Application Ref:	3/2021/0655	 Ribble Valley Borough Council www.ribblevalley.gov.uk
Date Inspected:	N/A	
Officer:	RB	
DELEGATED ITEM FILE REPORT:		NON MATERIAL AMENDMENT

Application Description:	Non material amendment to planning application 3/2005/0750. To reduce size of the approved extension, change in building materials and an additional velux roof light to the rear roof slope of the attached barn.
Site Address/Location:	Lower Monument House, Bolton by Bowland, BB7 4LY

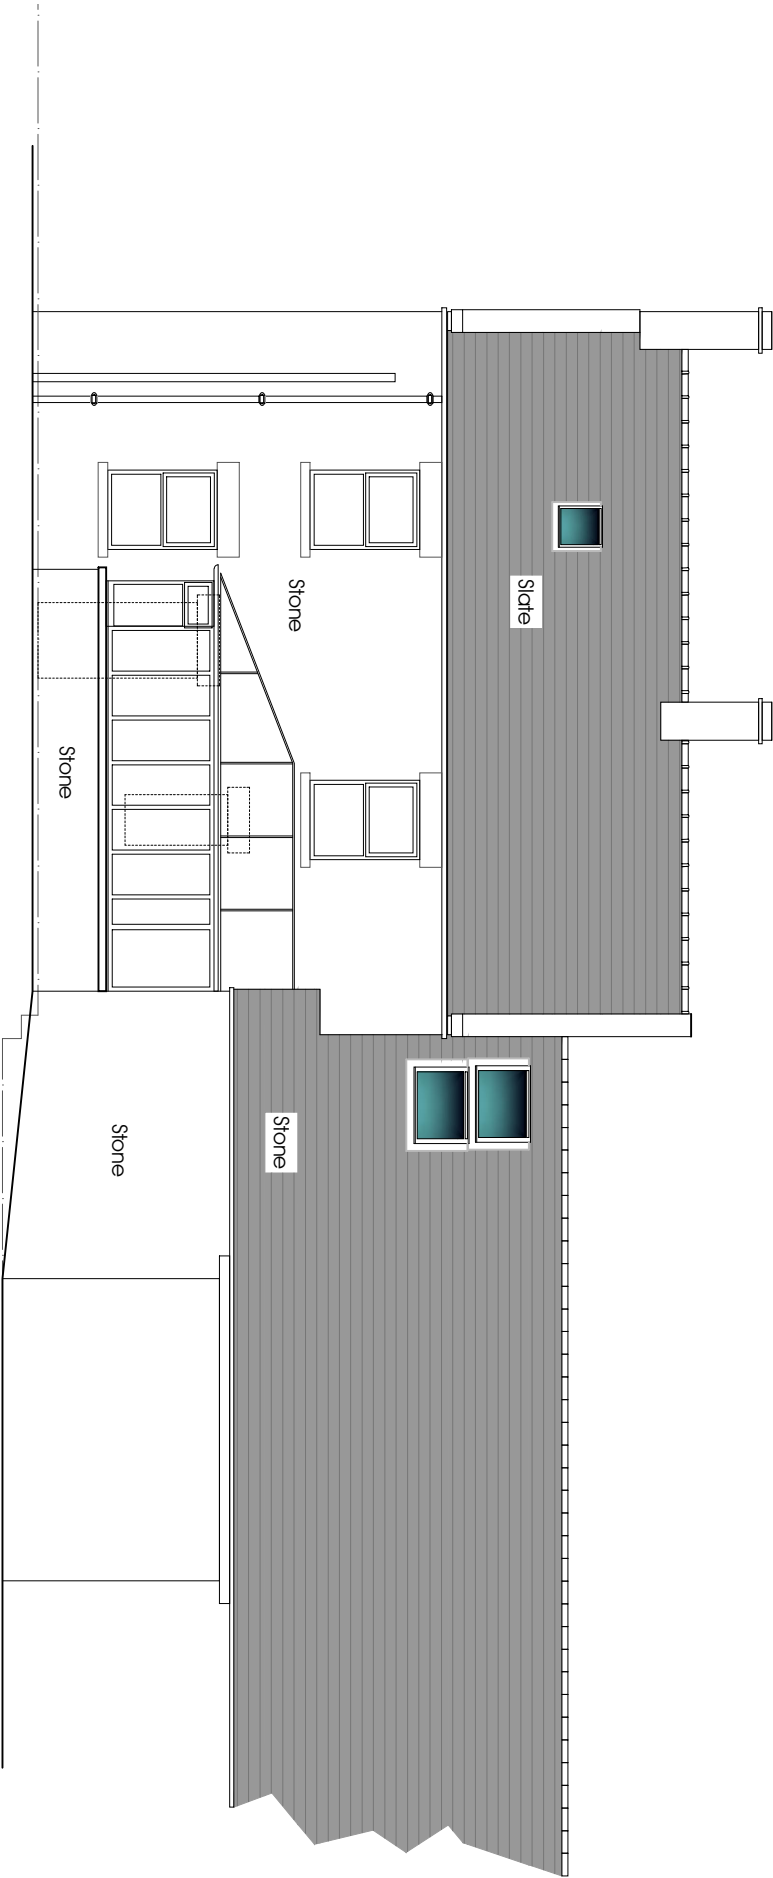
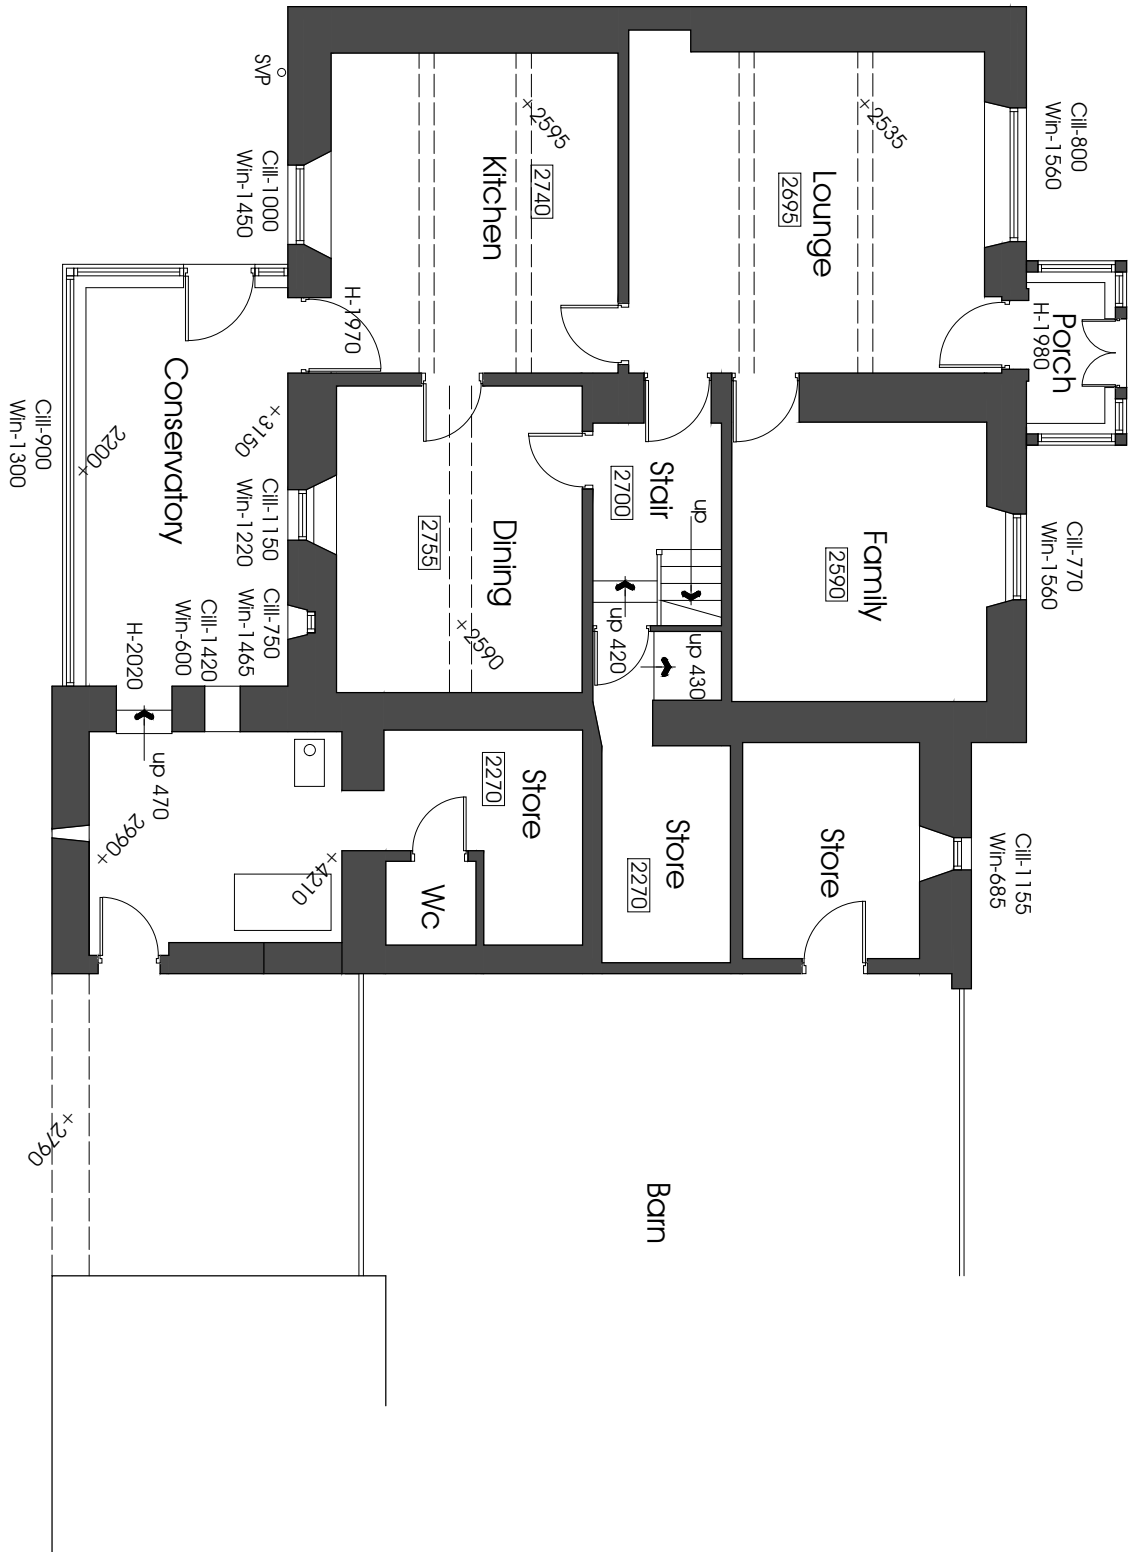
The non-material amendment proposes to change the external facing materials from the approved upvc and stone dwarf wall to cedar cladding to all elevations, zinc roof sheeting and aluminium glazing. The approved development proposed to match the main dwelling in terms of its building materials and the introduction of cedar cladding, zinc roof sheeting and aluminium glazing would result in a fundamental change in the design of the building as the use of cedar cladding, zinc sheeting and grey aluminium glazing would introduce a new building material not found on the existing dwelling.

Rear Elevation

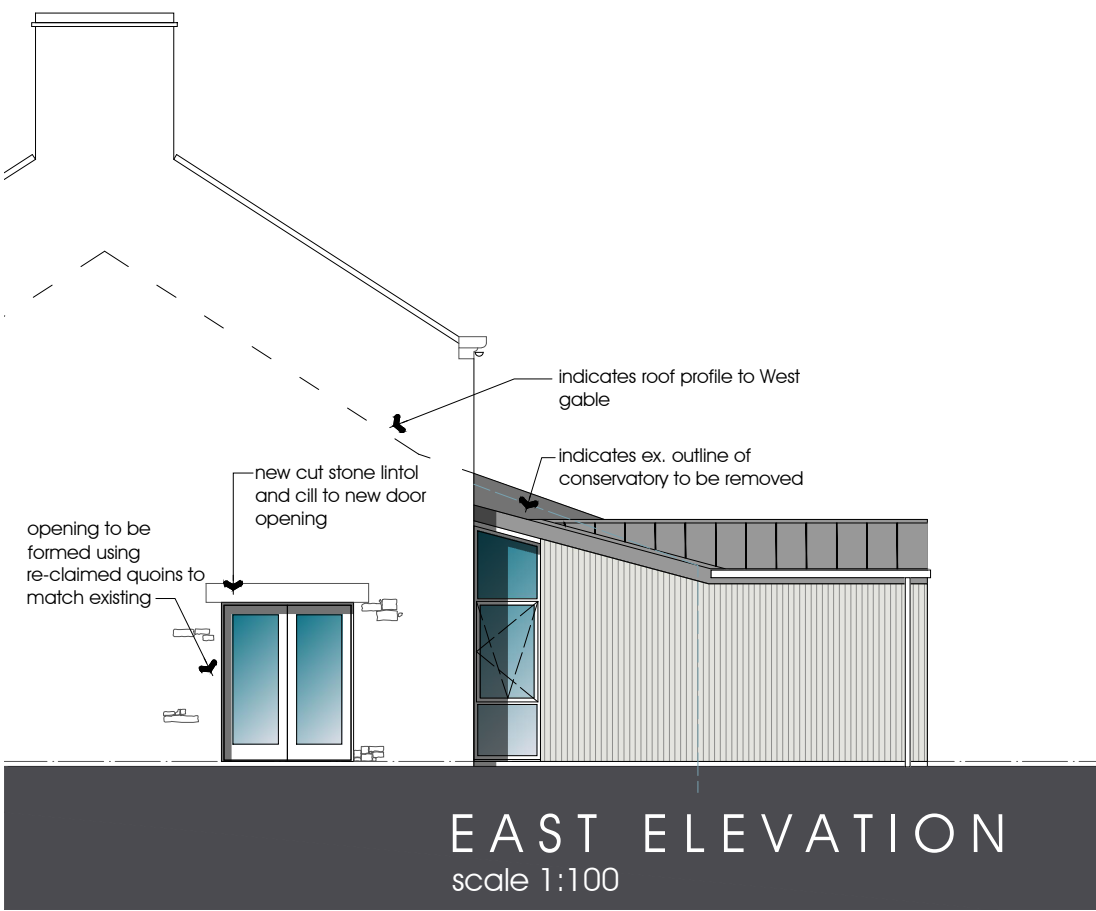
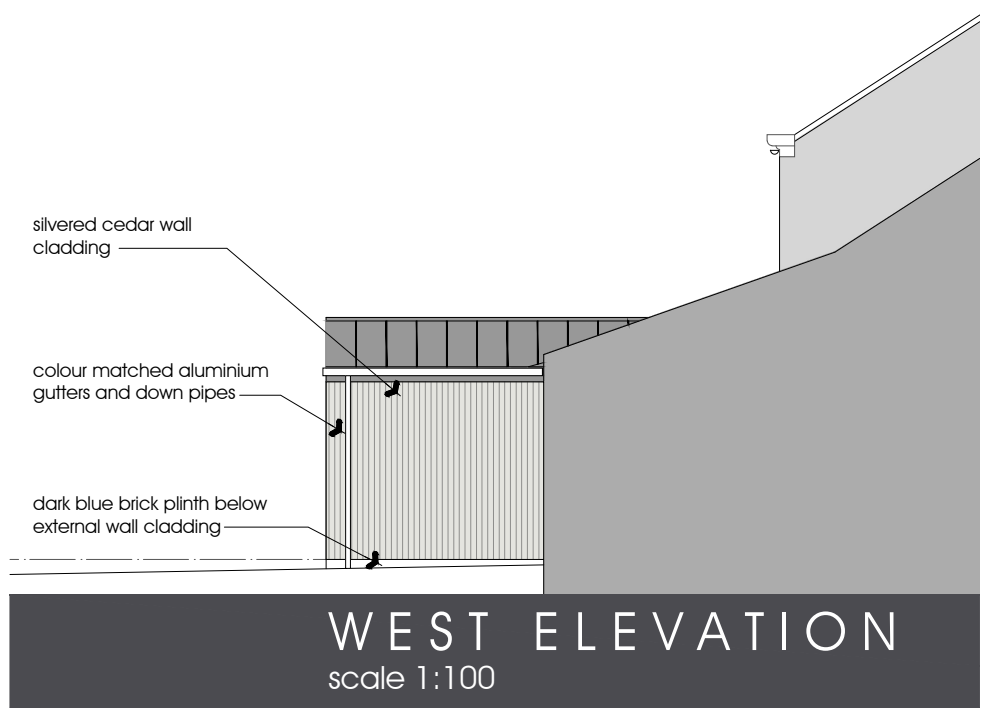
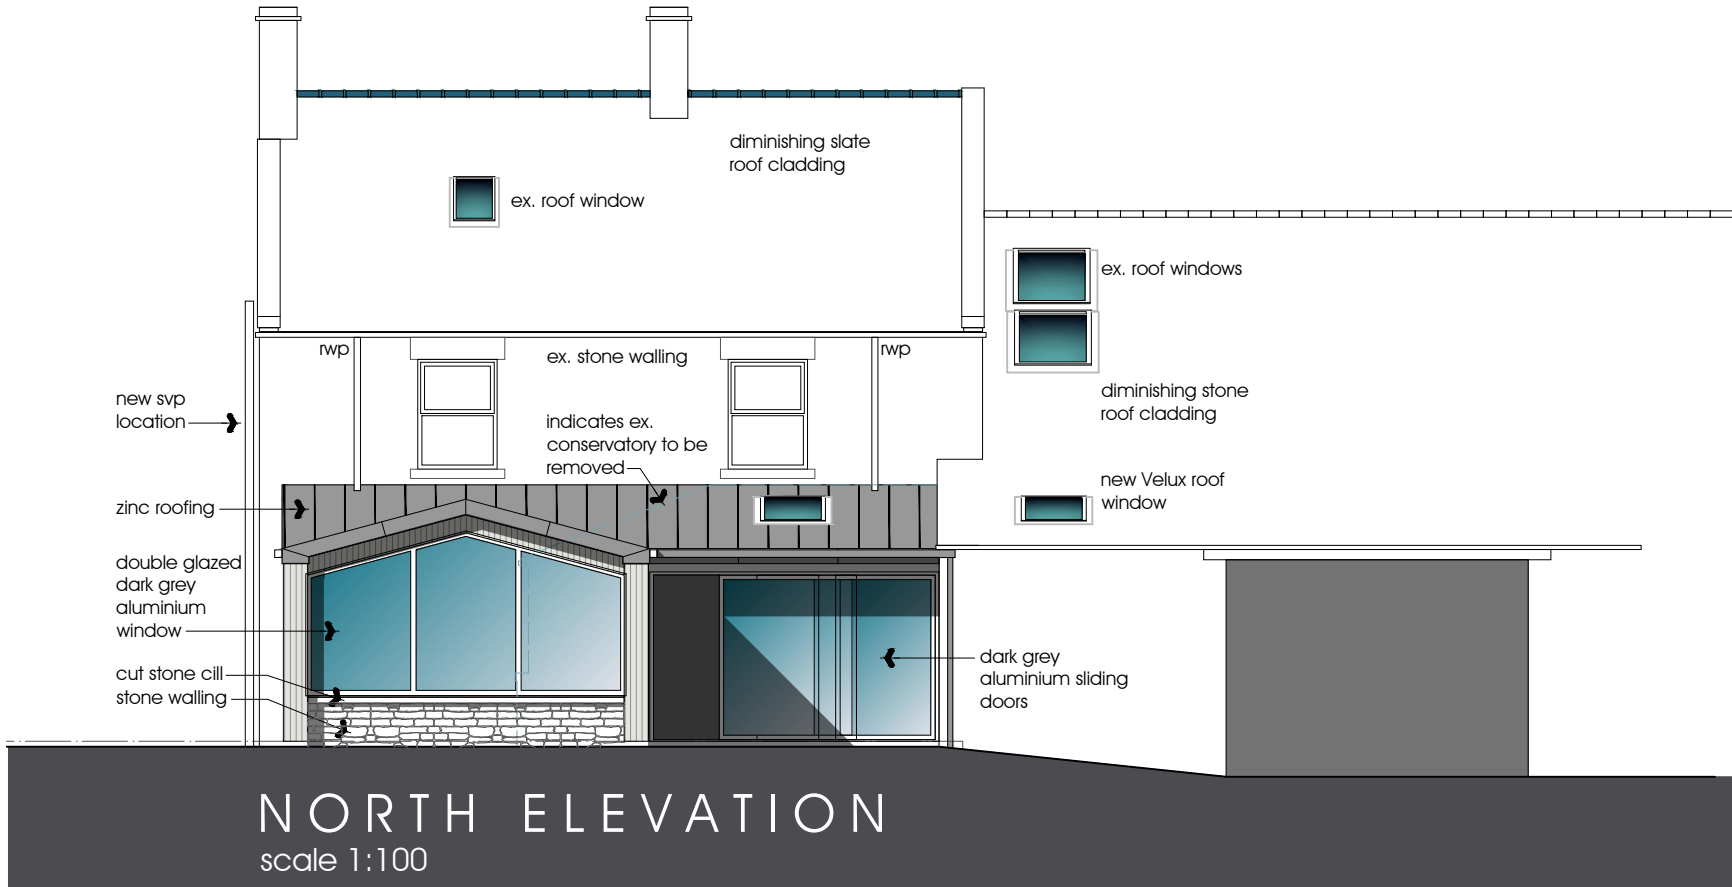
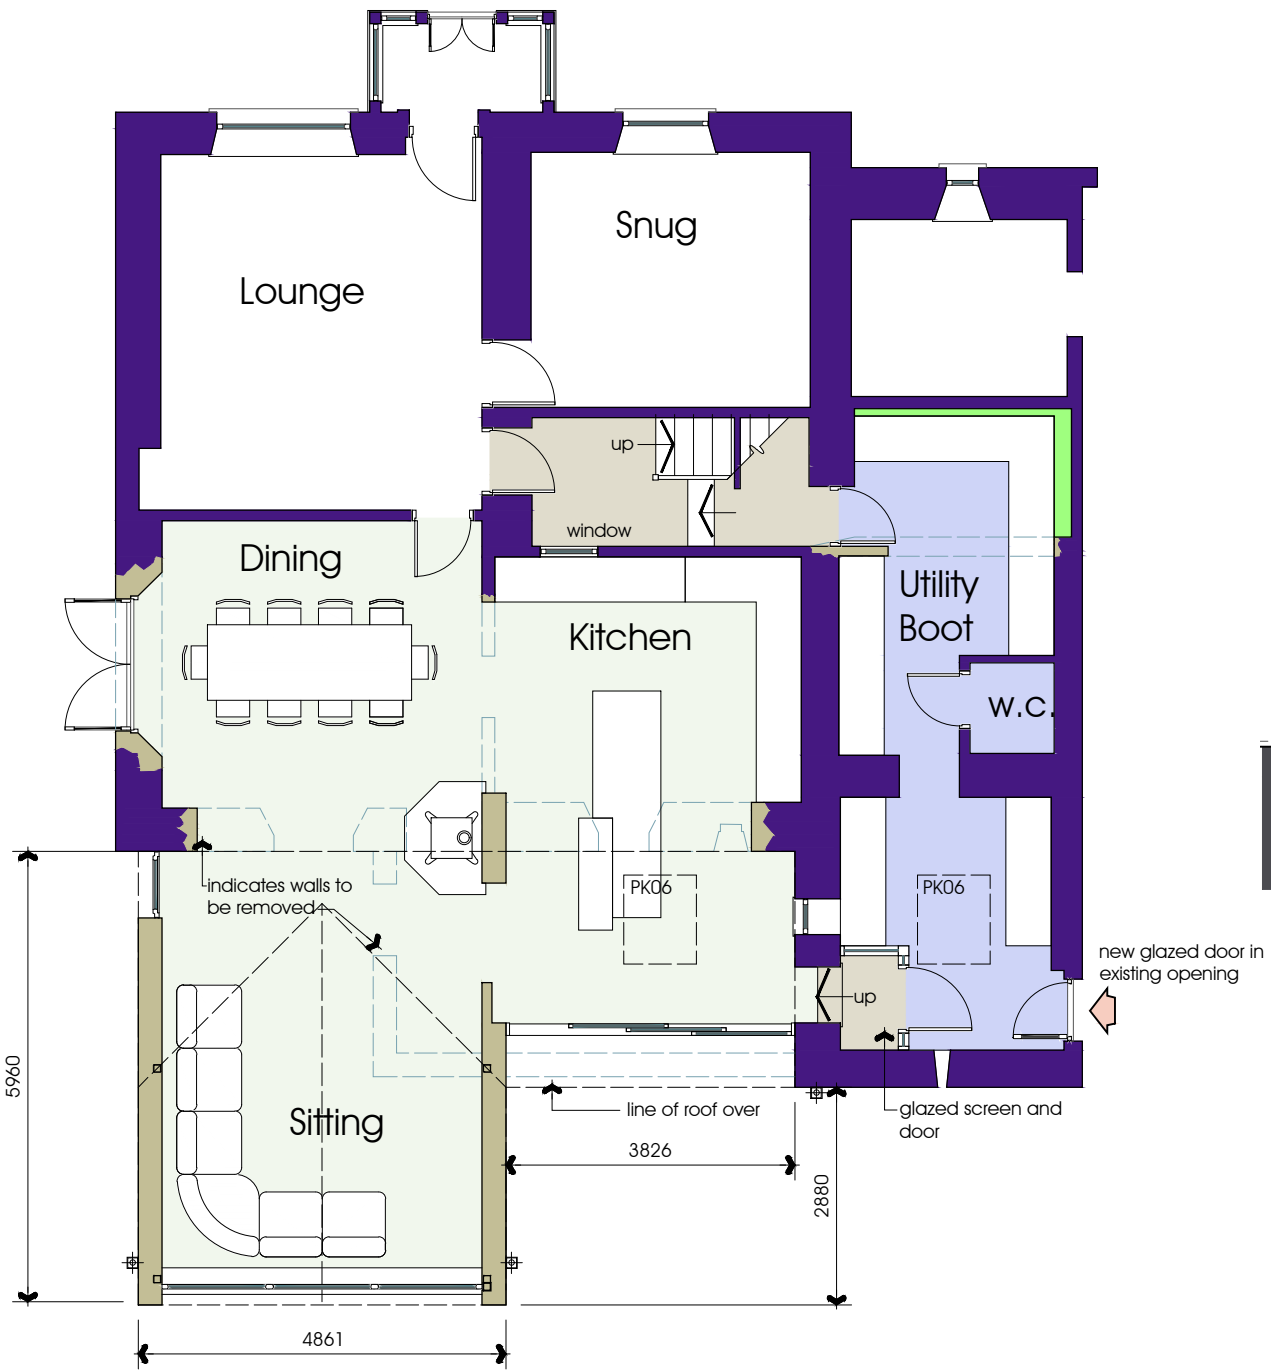
Furthermore, the amended plans proposed an additional roof light in the rear roof slope of the attached barn. It is considered that the introduction of a rooflight on a barn has a material impact on the character of the barn and therefore cannot be considered non material.
